# KITTITAS COUNTY

### MEMORANDUM

TO: Community Development Services  
FROM: Taylor Gustafson, Environmental/Transportation Planner TG  
DATE: August 9, 2018  
SUBJECT: County Survey review of Short Plat LPF 18-00003 (Swauk Valley Ranch)  
(Despite CDS labeling this as a 'LPF', this is a 4 lot Short Plat, and will be reviewed as such. Preliminary Long Plat review for this application was under LP-17-00007)

SWAUK RANCH CONSERVATION PLAT

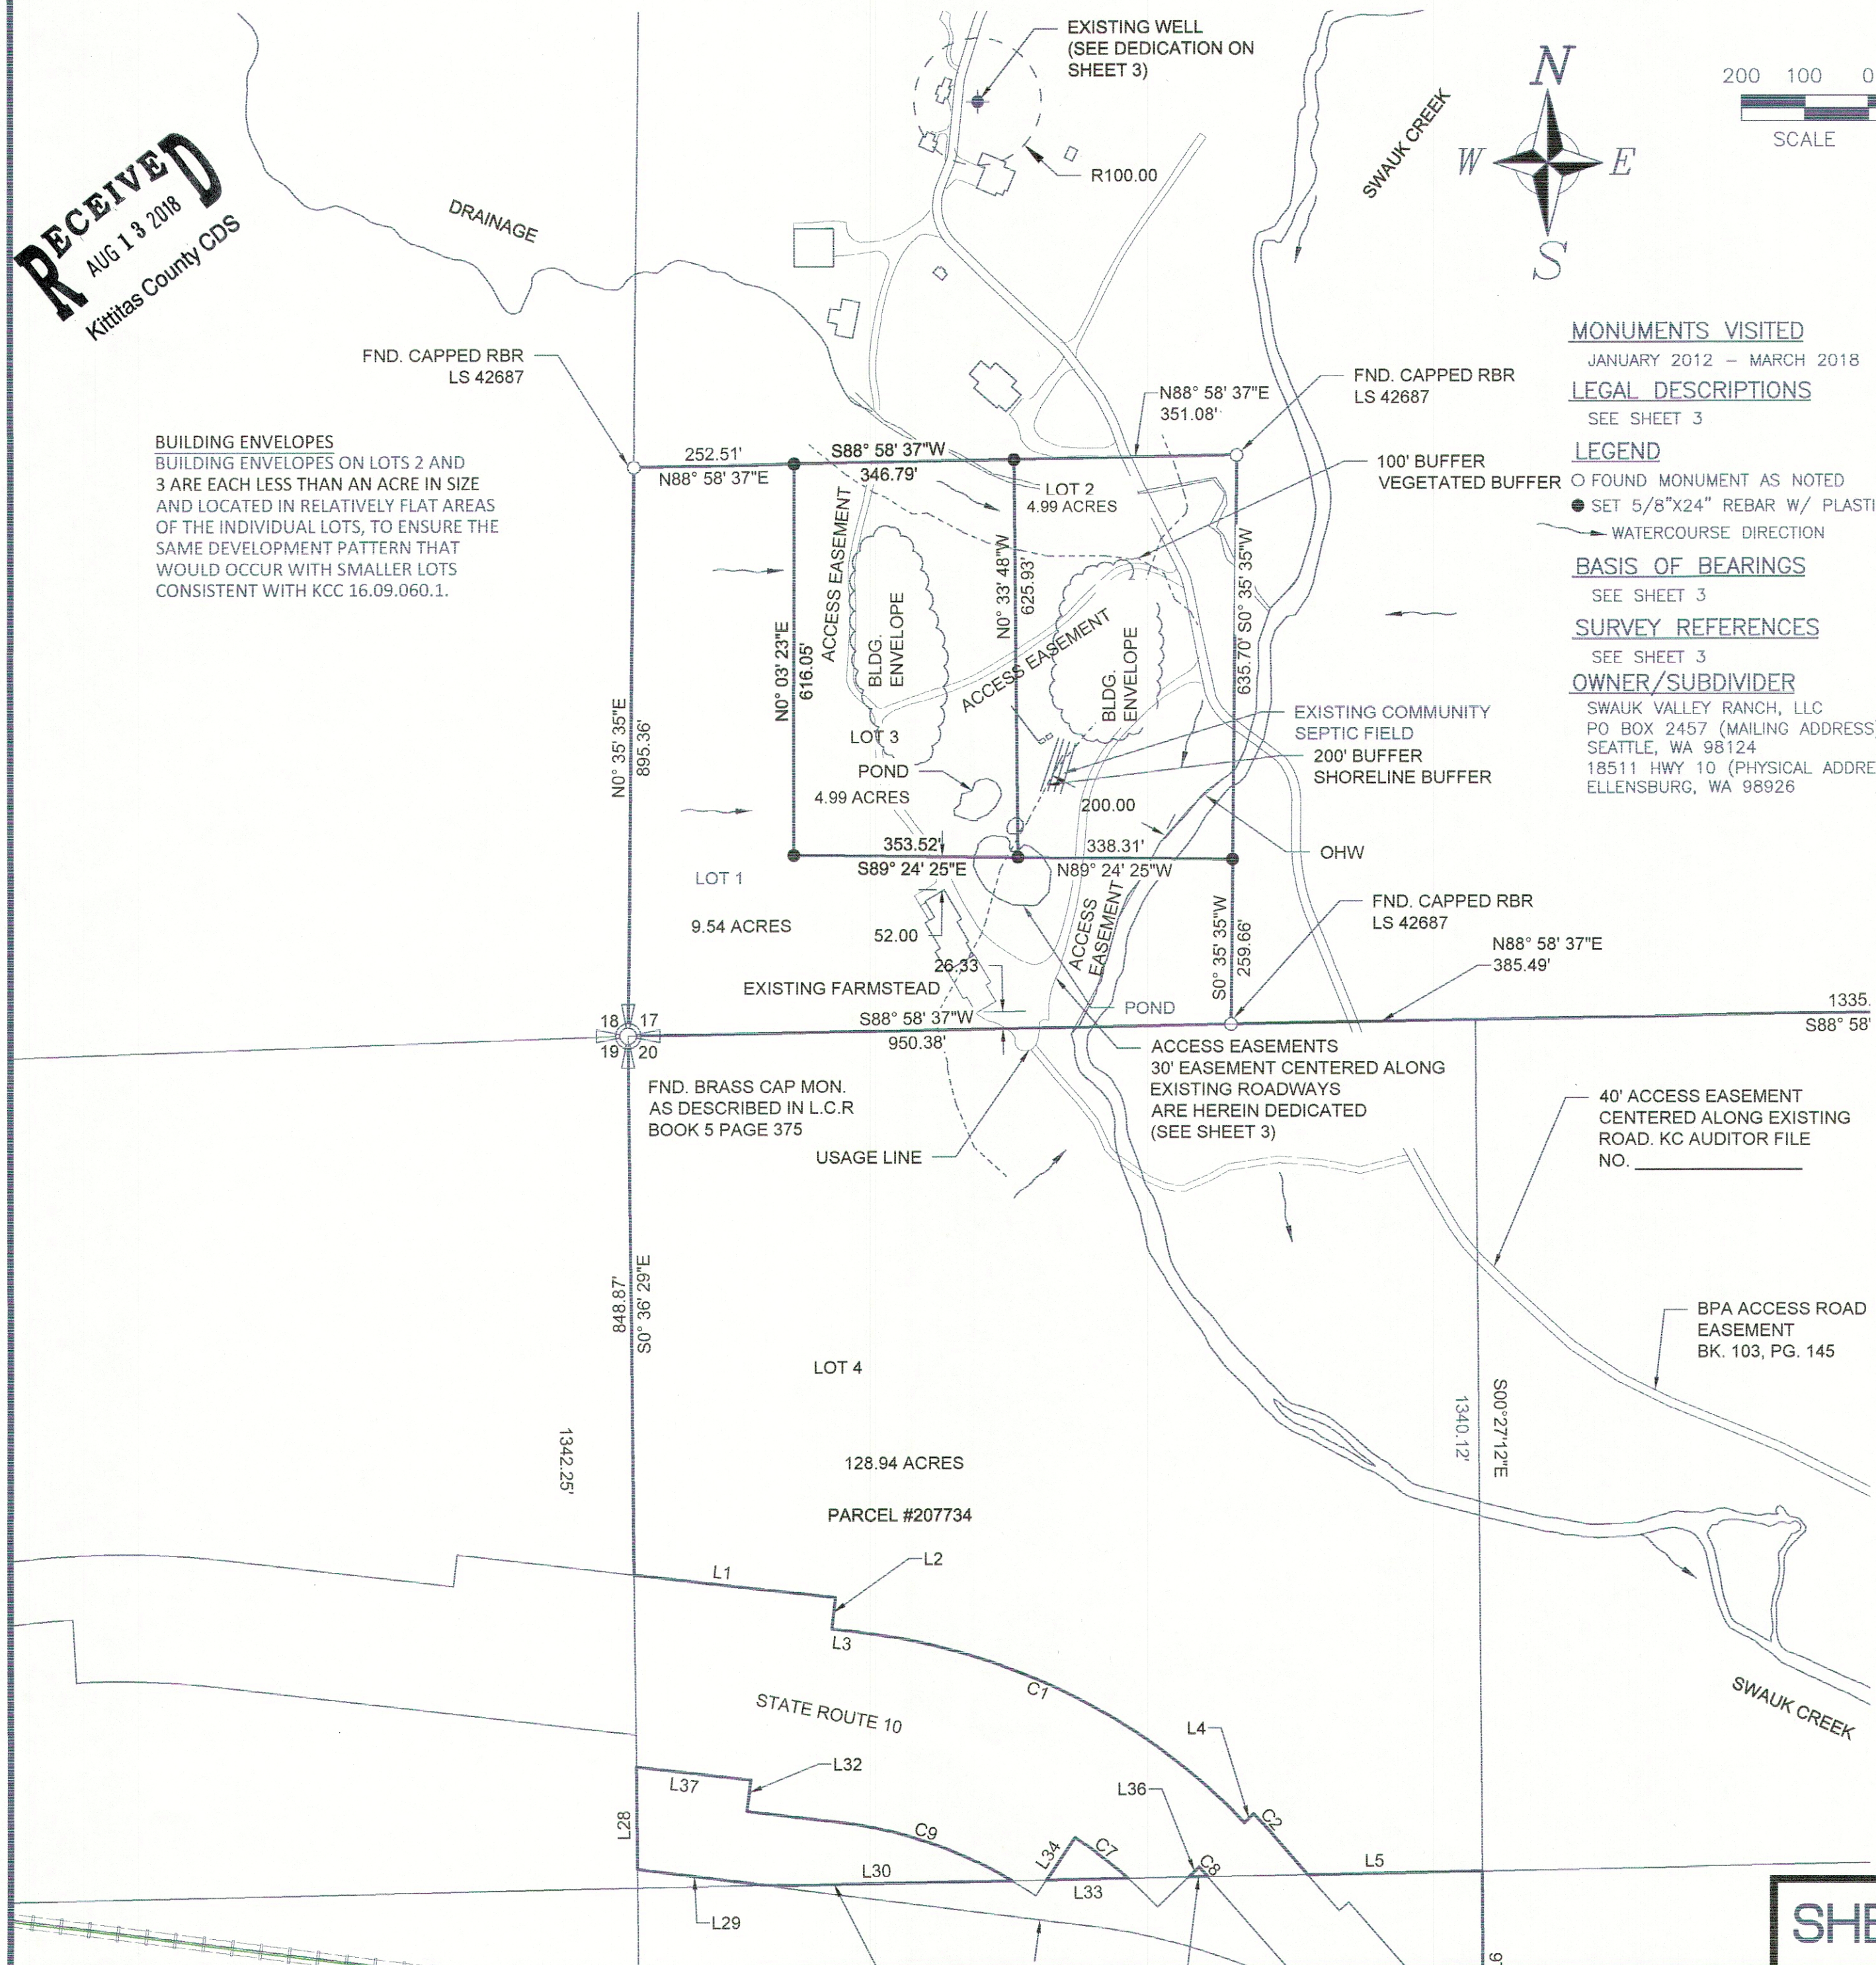
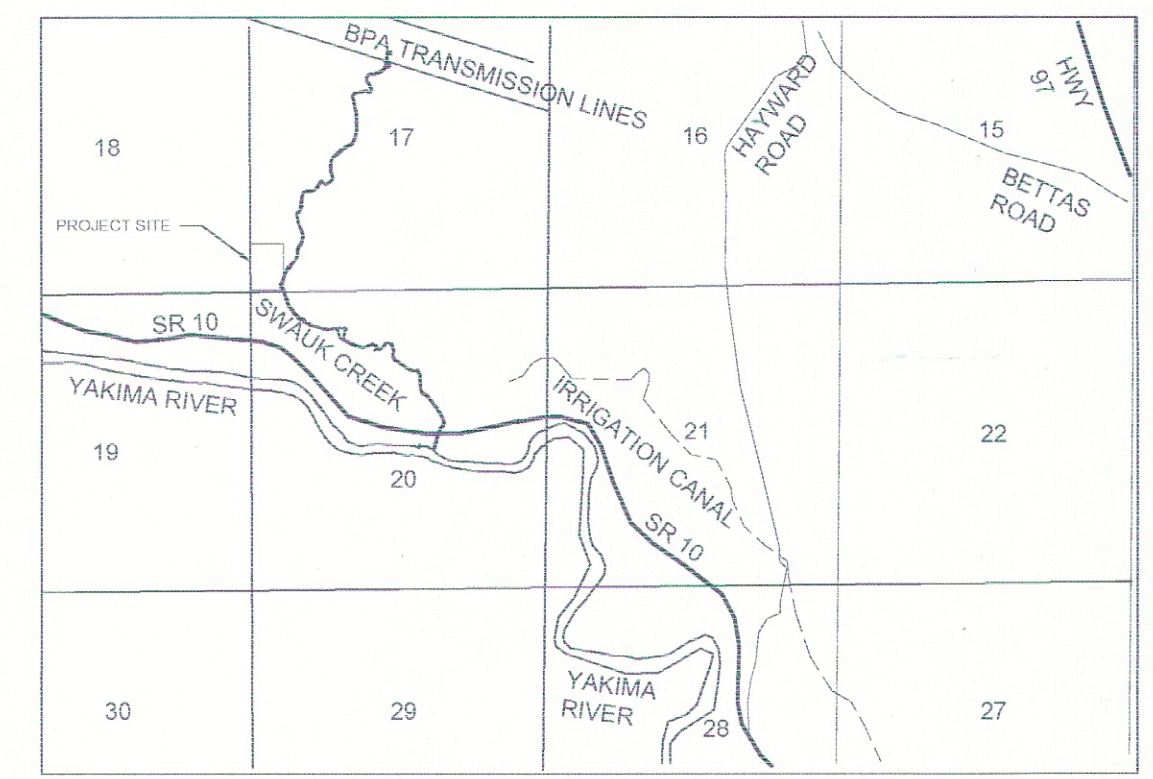
1. Per a phone conversation with Dustin Conroy with Pioneer Surveying, the access easements were all to be dedicated via this plat. If that is the case, the easements shown must be labeled as "herein dedicated" or similar. Additionally, easements that are centered about the existing roadways need to be labeled as such, ("along existing road" is not sufficient). All easements created must also provide an easement width. For required widths, coordination with Kelly Bacon, county access technician is suggested. The portion of the access easement lying outside the platted area will need to be dedicated via a separate document and noted as such.
2. Per phone conversation, a note was to be added referencing the dedication for the area near the well to clarify well access to owners of the plat.
